5 August 2019

Mr David Gibson
Team Leader - Social Infrastructure Assessments
NSW Department of Planning, Industry and Environment
320 Pitt Street
Sydney NSW 2000

RE: SECTION 4.55(1A) MODIFICATION TO AMEND SSD 14_6848 IN RELATION TO THE STAGE 3B DEVELOPMENT AT LISMORE BASE HOSPITAL

1 GA - Level 03 3B2
A30001 1 : 200

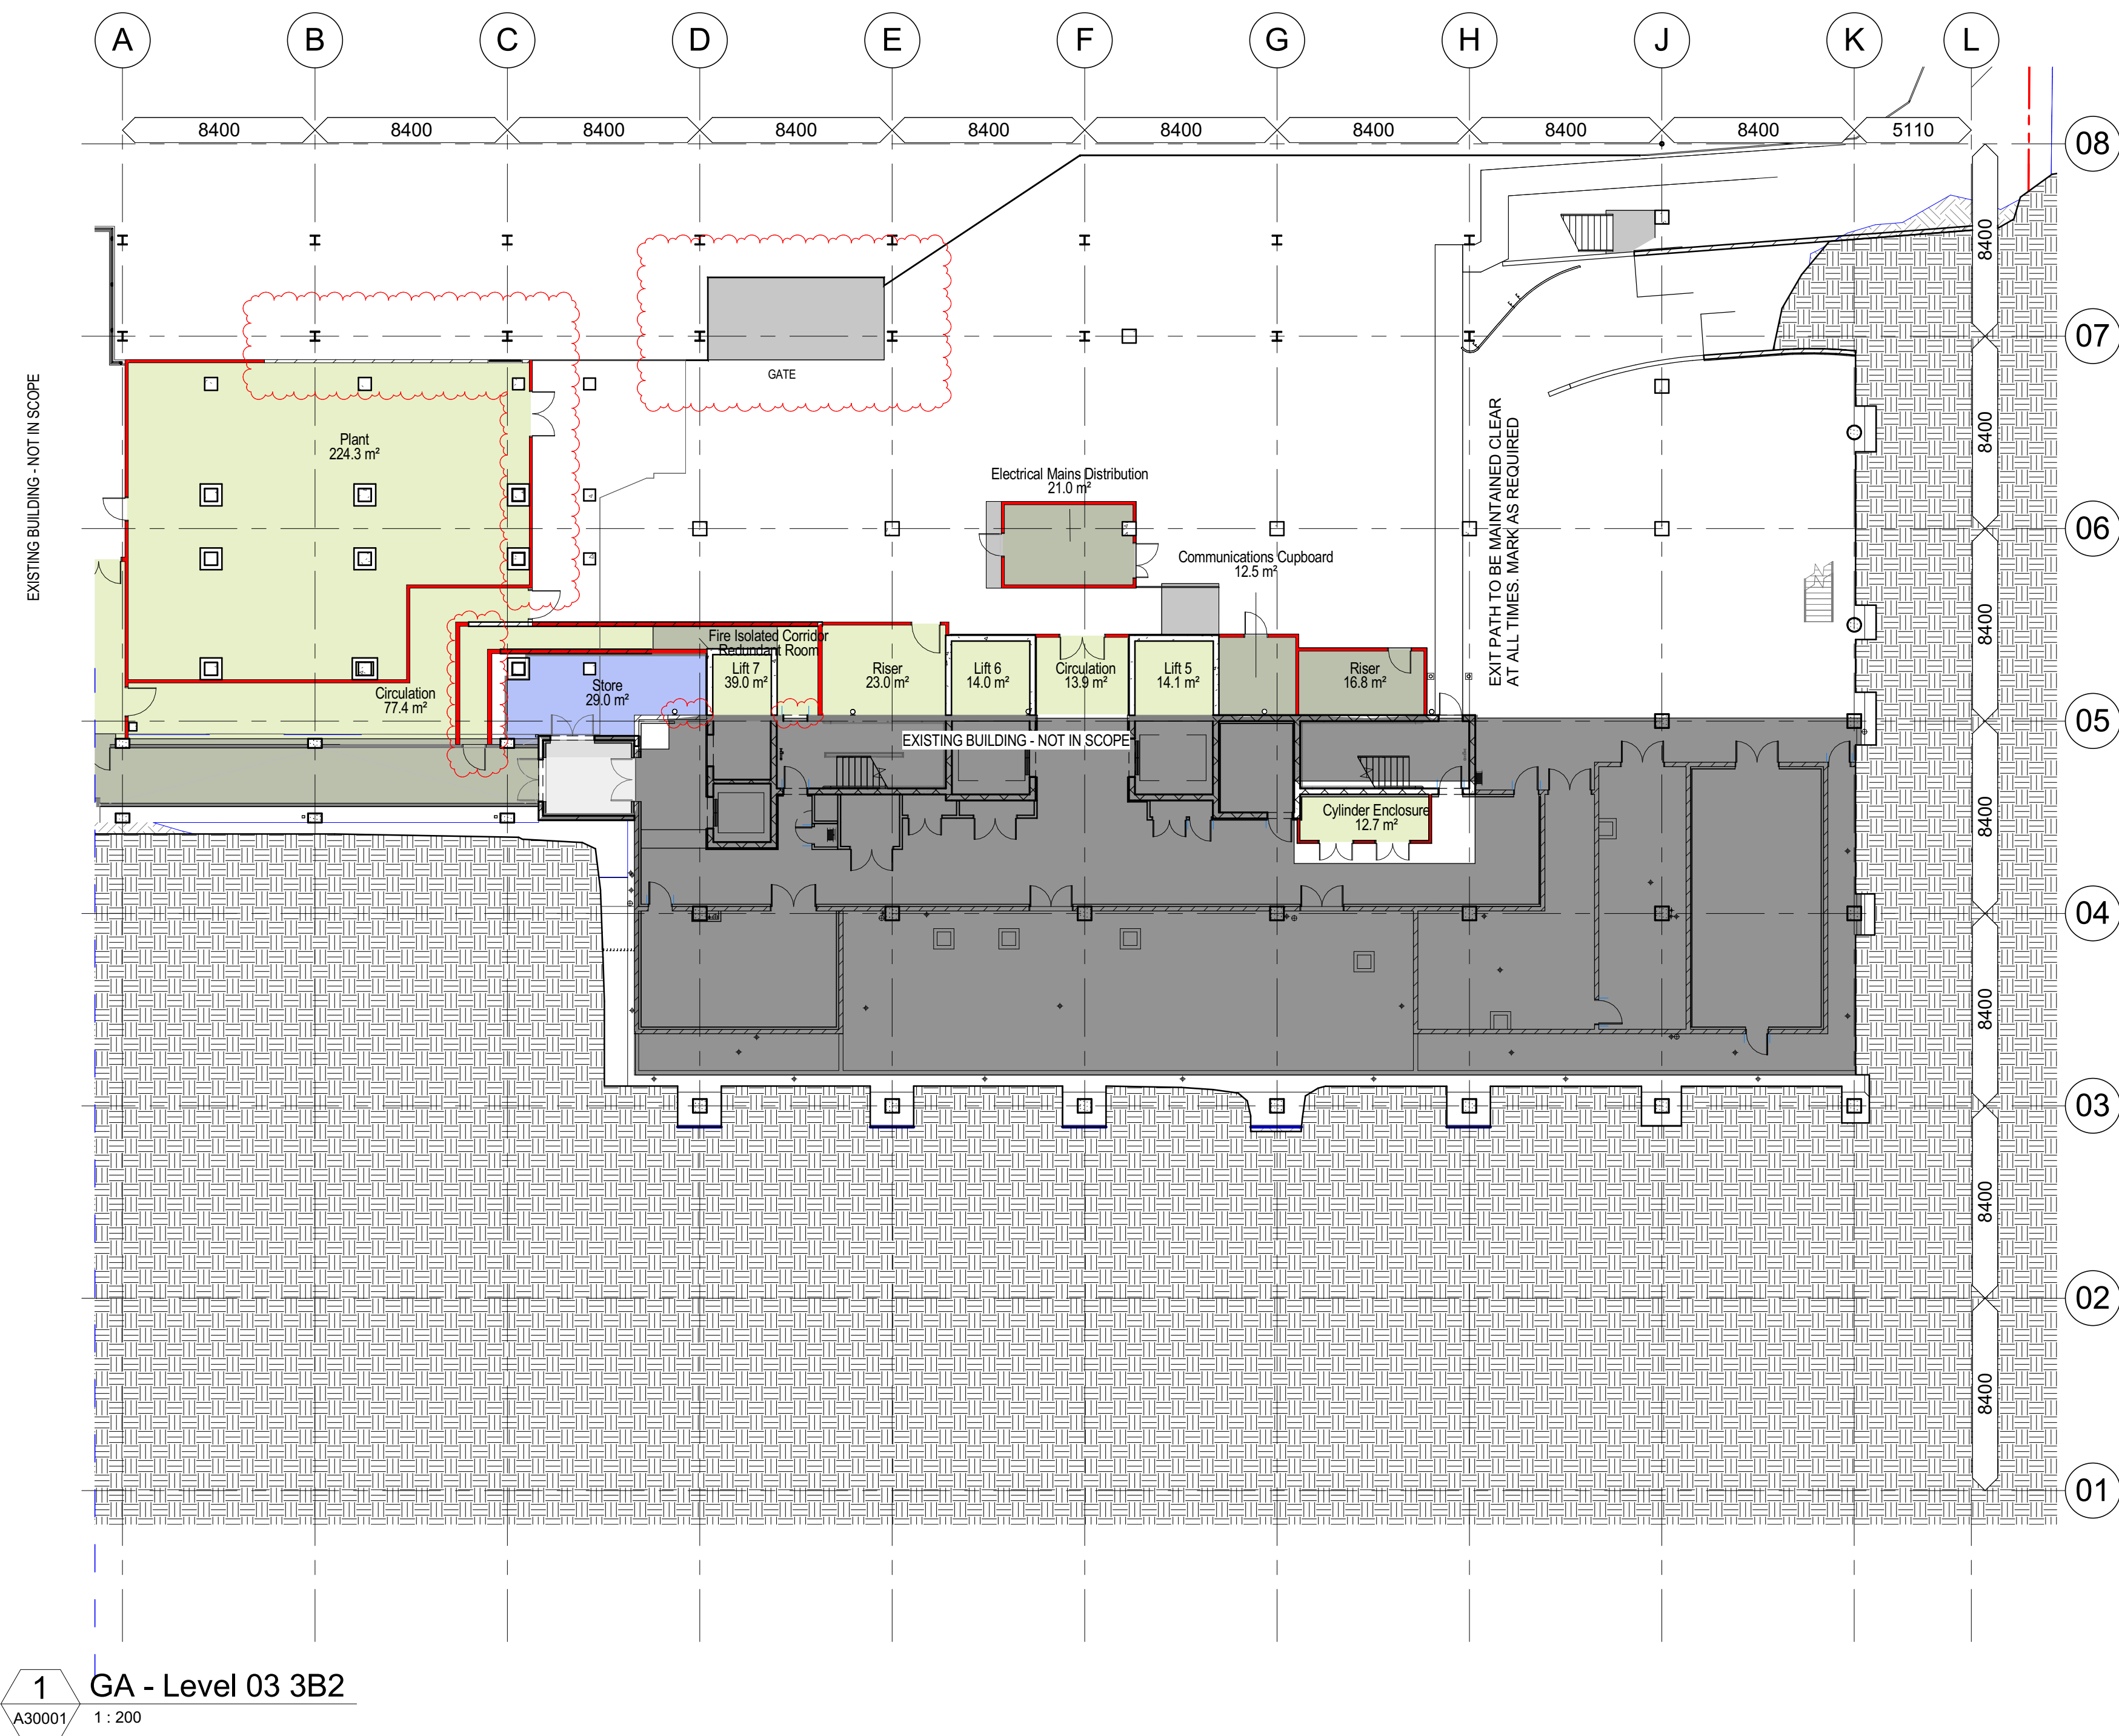
- Modifications to Level 3 as follows:
 - Reduction in the extent of plant;
 - Removal of the chiller enclosure;
 - Realignment of a fire passage
 - Minor modification to the extent louvres in nominated locations;

- Removal of the fire passage door at 'stair 1' (to satisfy fire engineering requirements); and
 - Relocation of the door to the main plant space further north to better align with final plant layouts.

Schedule of Changes - North Elevation 3B2	
Item	Comments
1	Quench pipe design adjusted, level 5 grid H
2	Security gate level 4 grid H
3	Block wall alignment adjusted west grid C
4	Mechanical duct shown grid B
5	Extent of louvres adjusted grid C

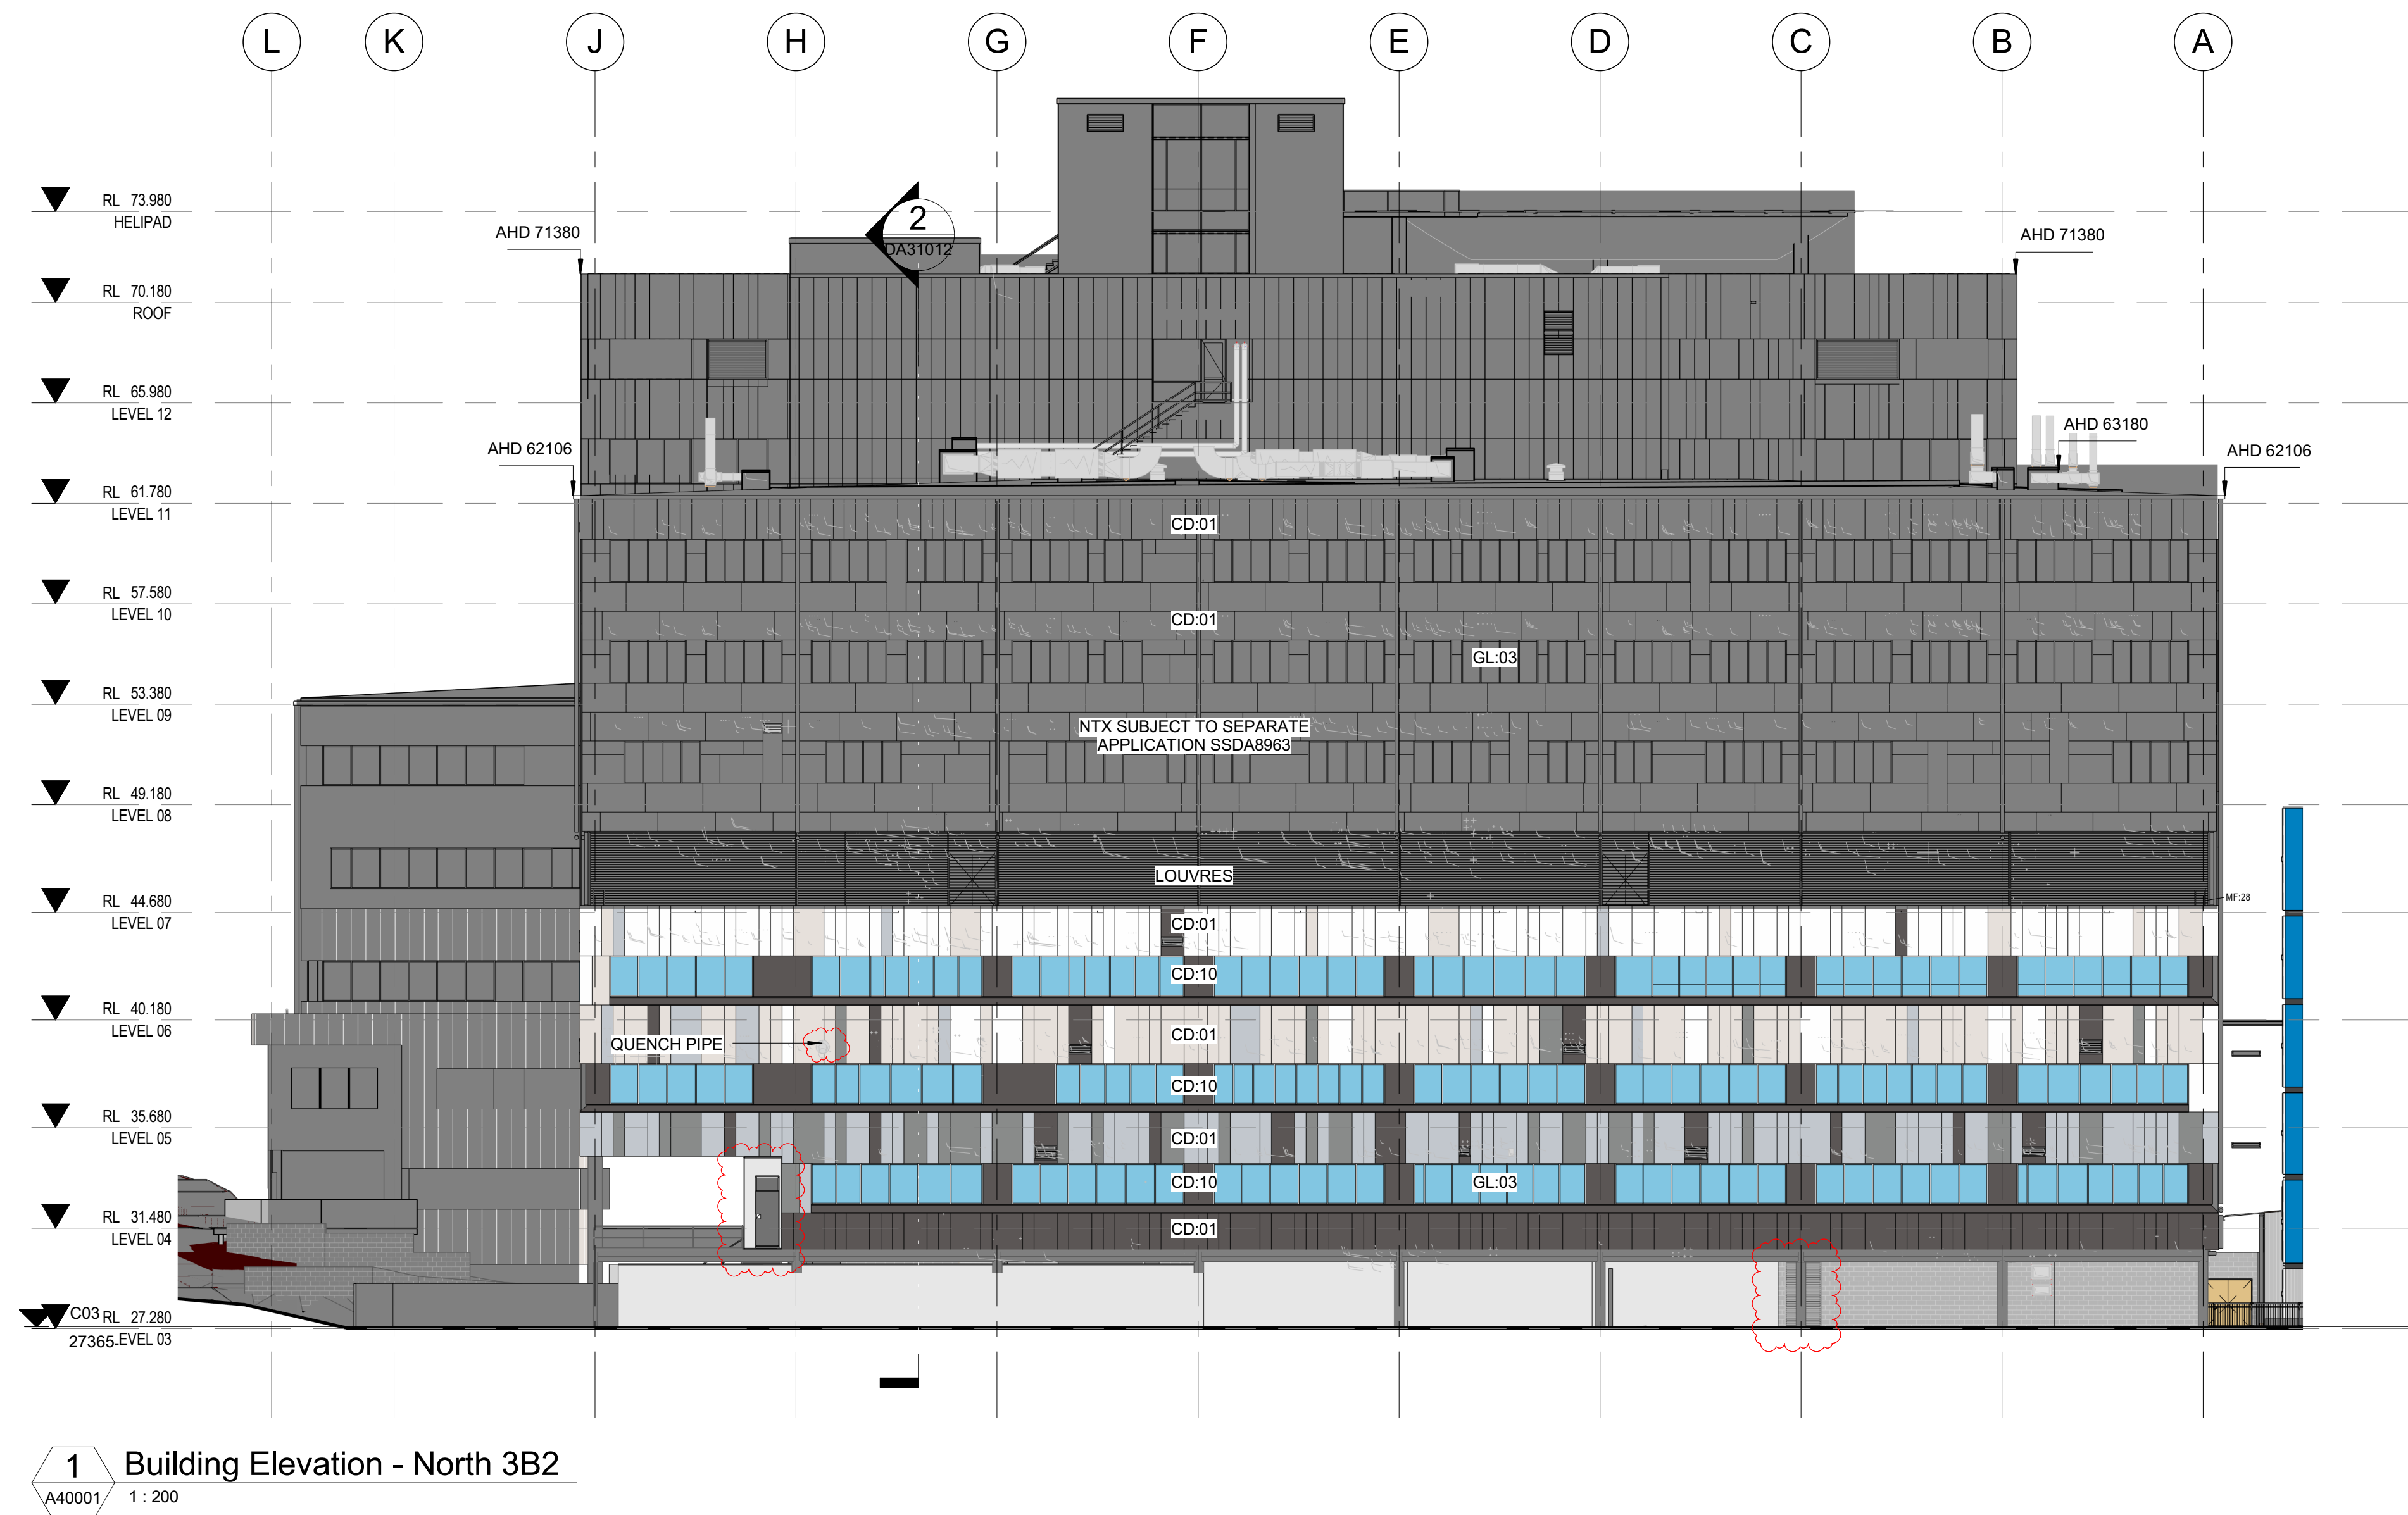
- Northern Façade: adjustment of the approved quench pipe location and design at Level 5, inclusion of a security gate at Level 4, minor adjustments to the wall alignment and extent of louvres and inclusion of a mechanical relief air duct at Level 3; and
